# Widefield Parks & Recreation

February 7, 2022

## WIDEFIELD SCHOOL DISTRICT 3 DEVELOPMENT PLAN

LANDSCAPE PLAN

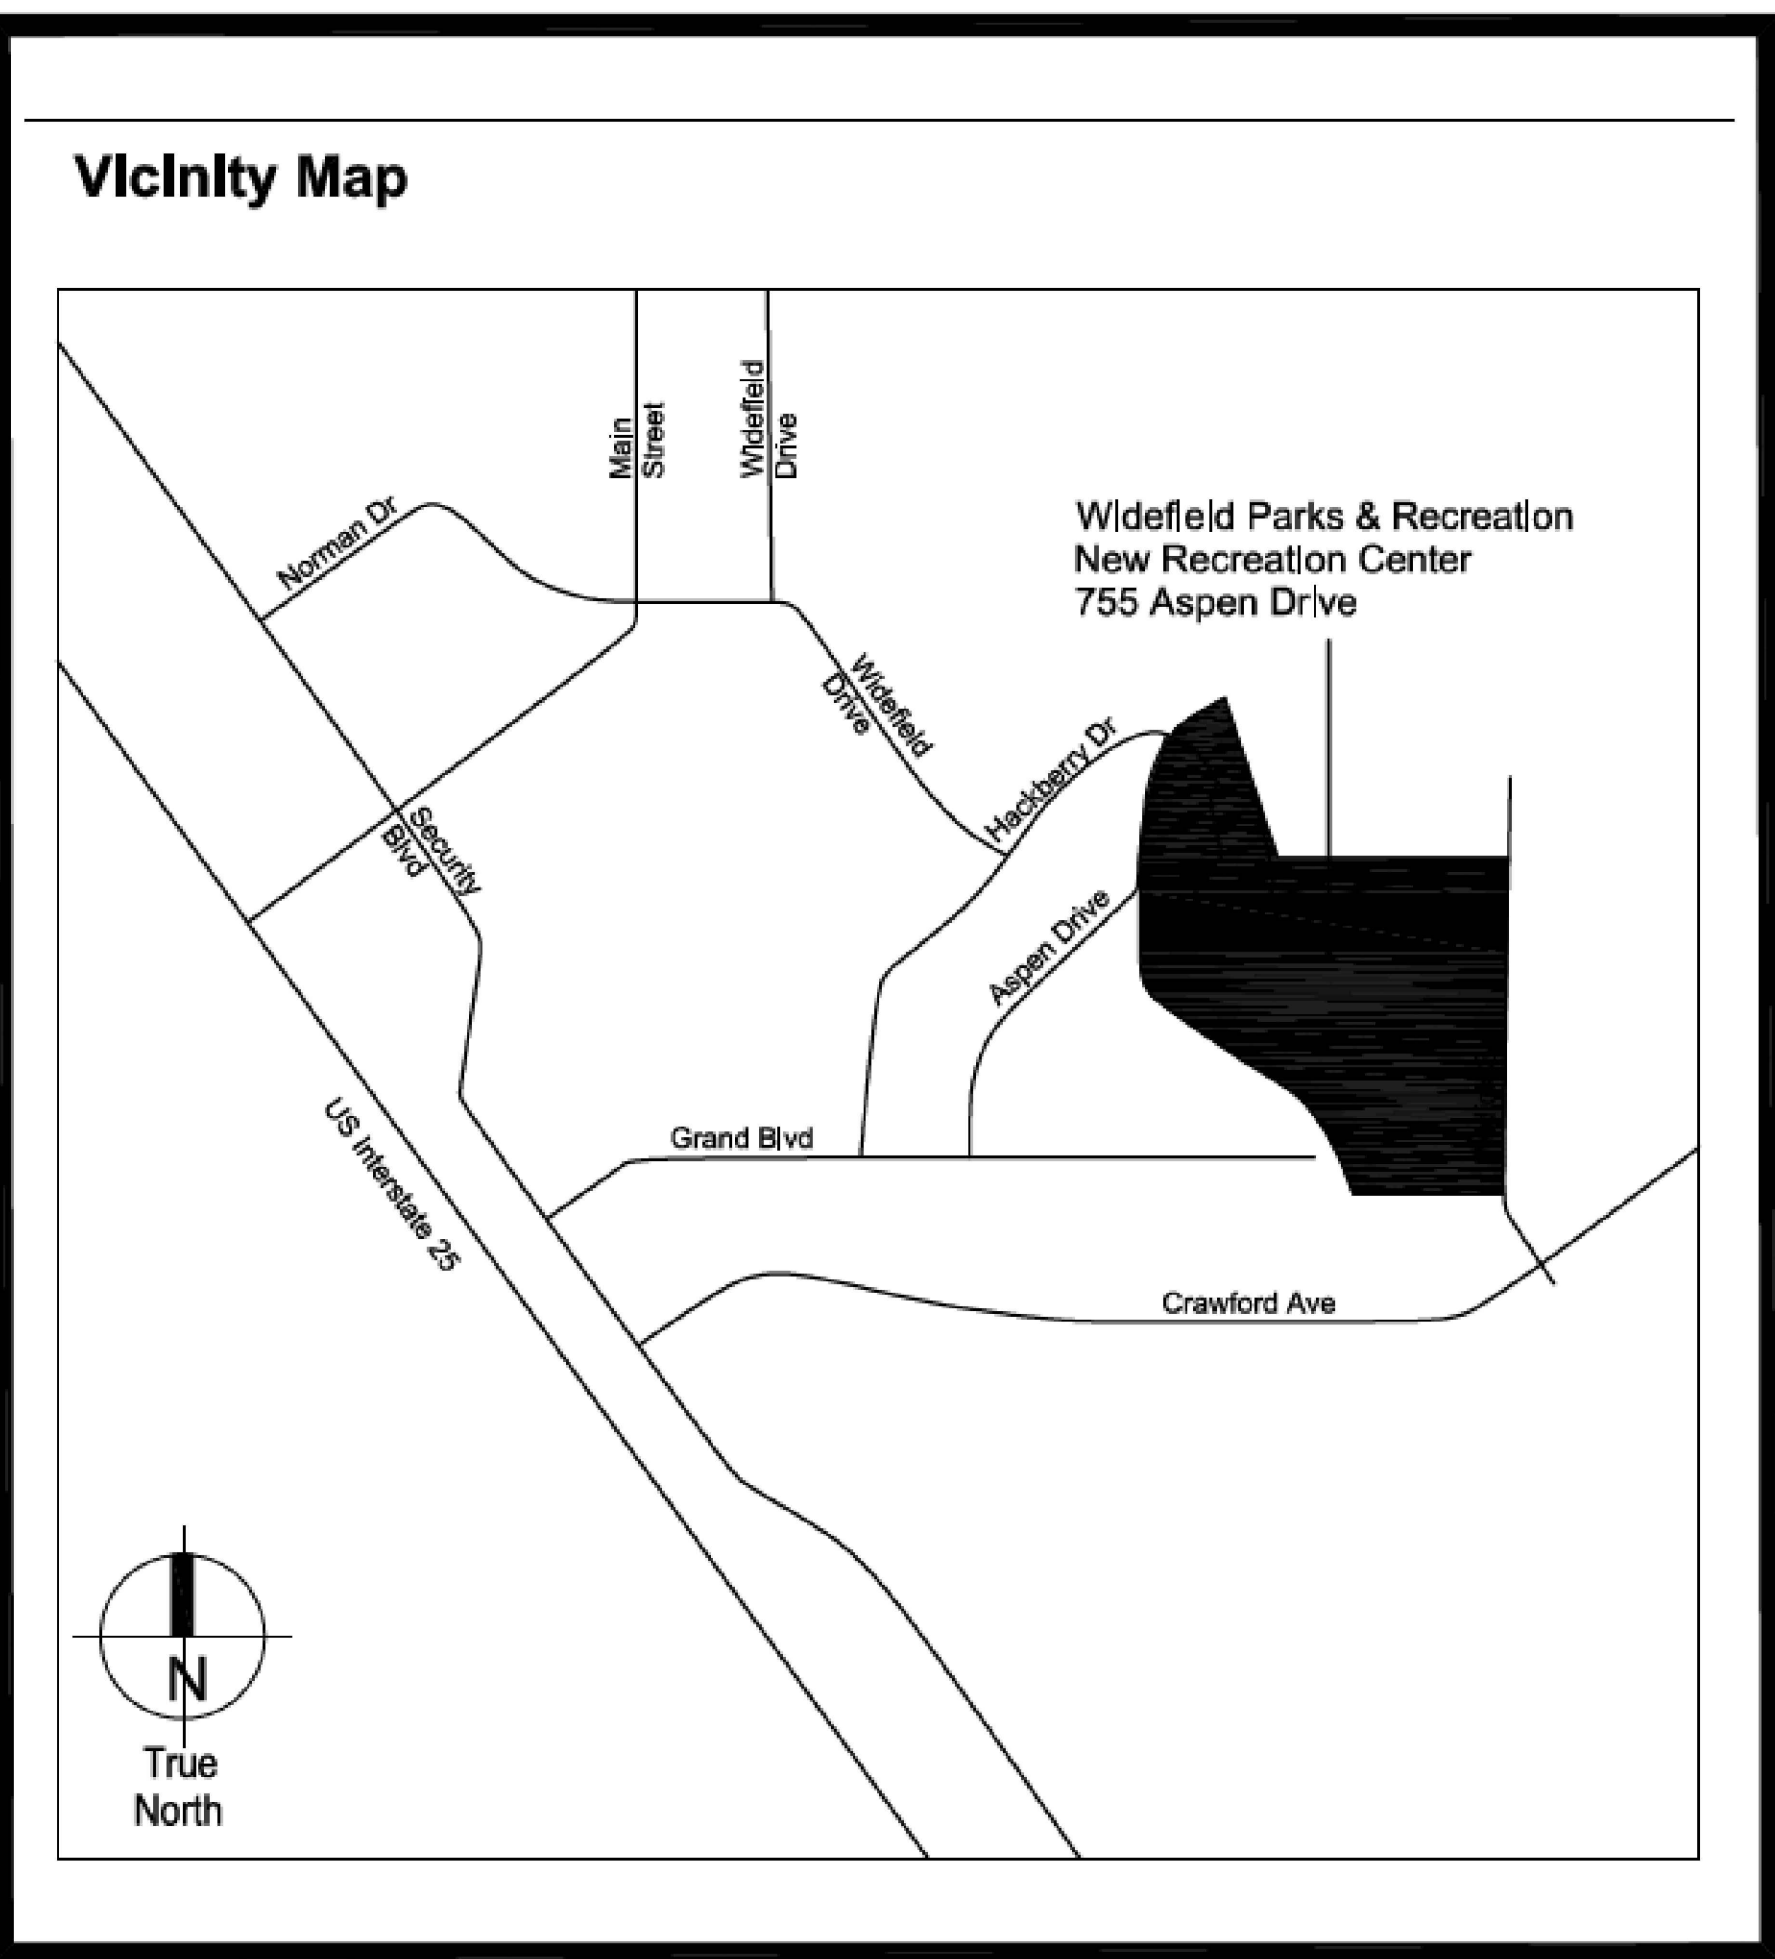
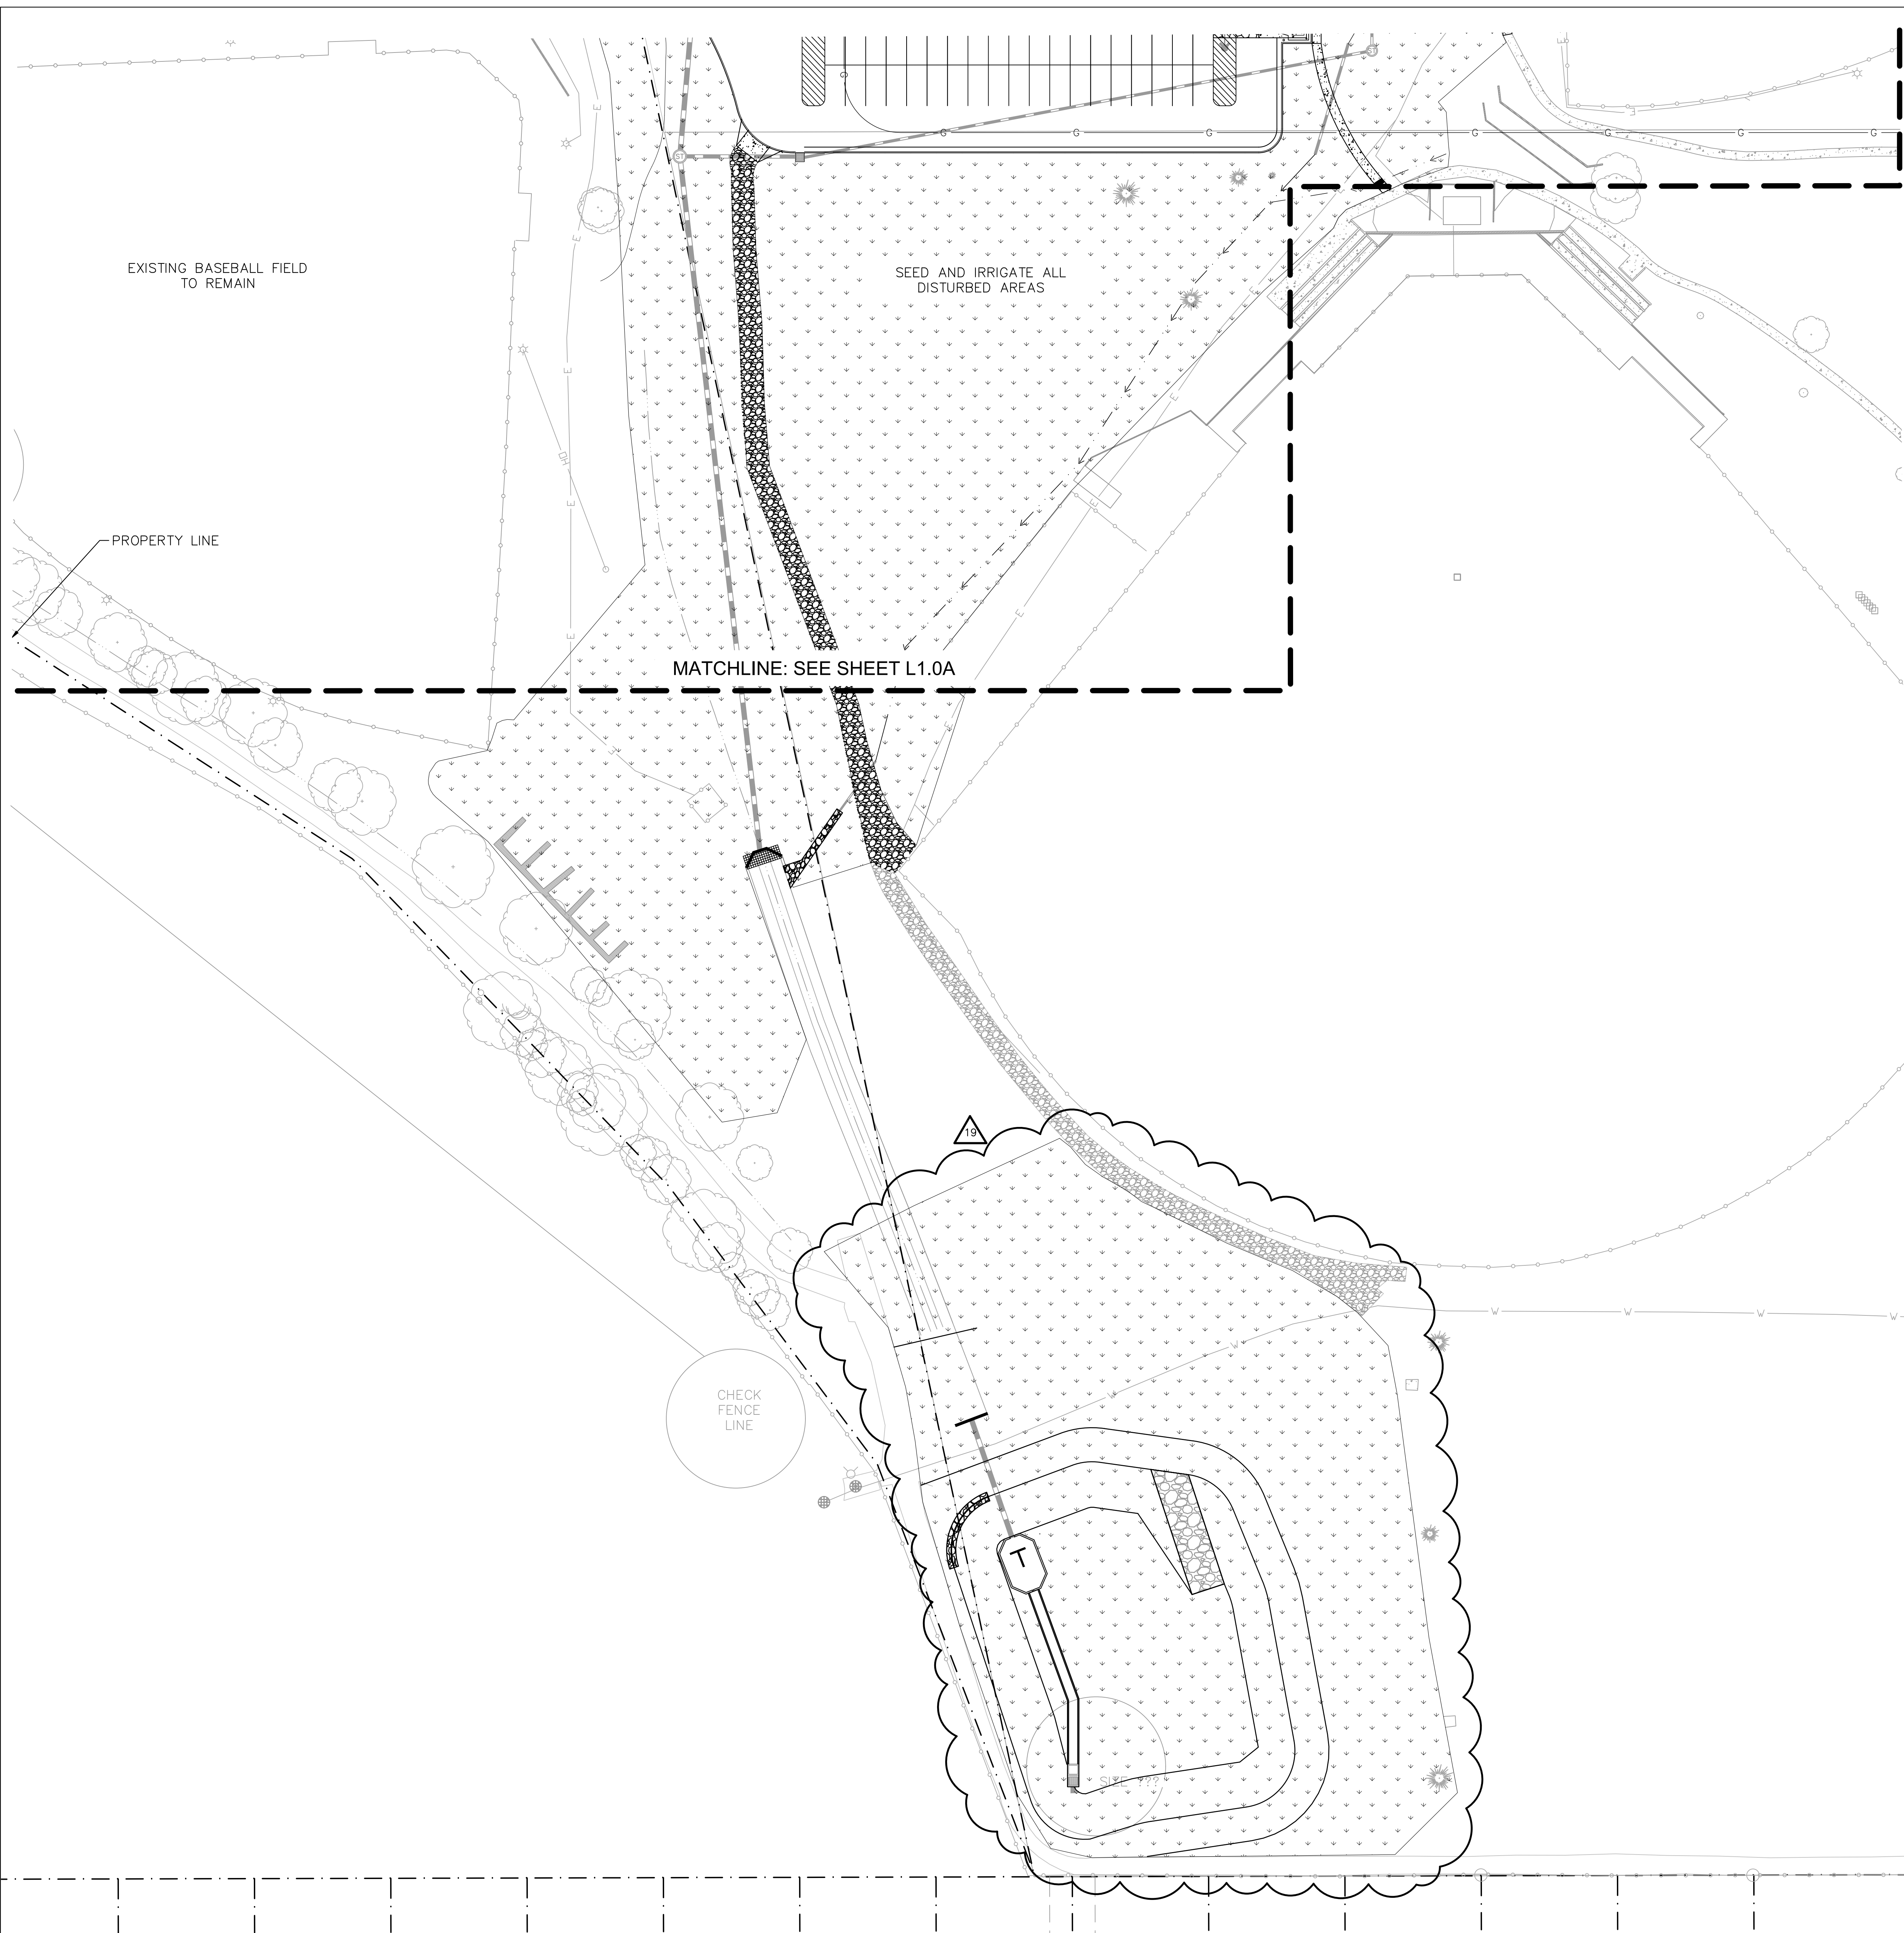
Alternate landscape request noted - however, justification per LDC Sec. 6.2.2.A.1 is required. Please provide an analysis of the criteria in that Code section.
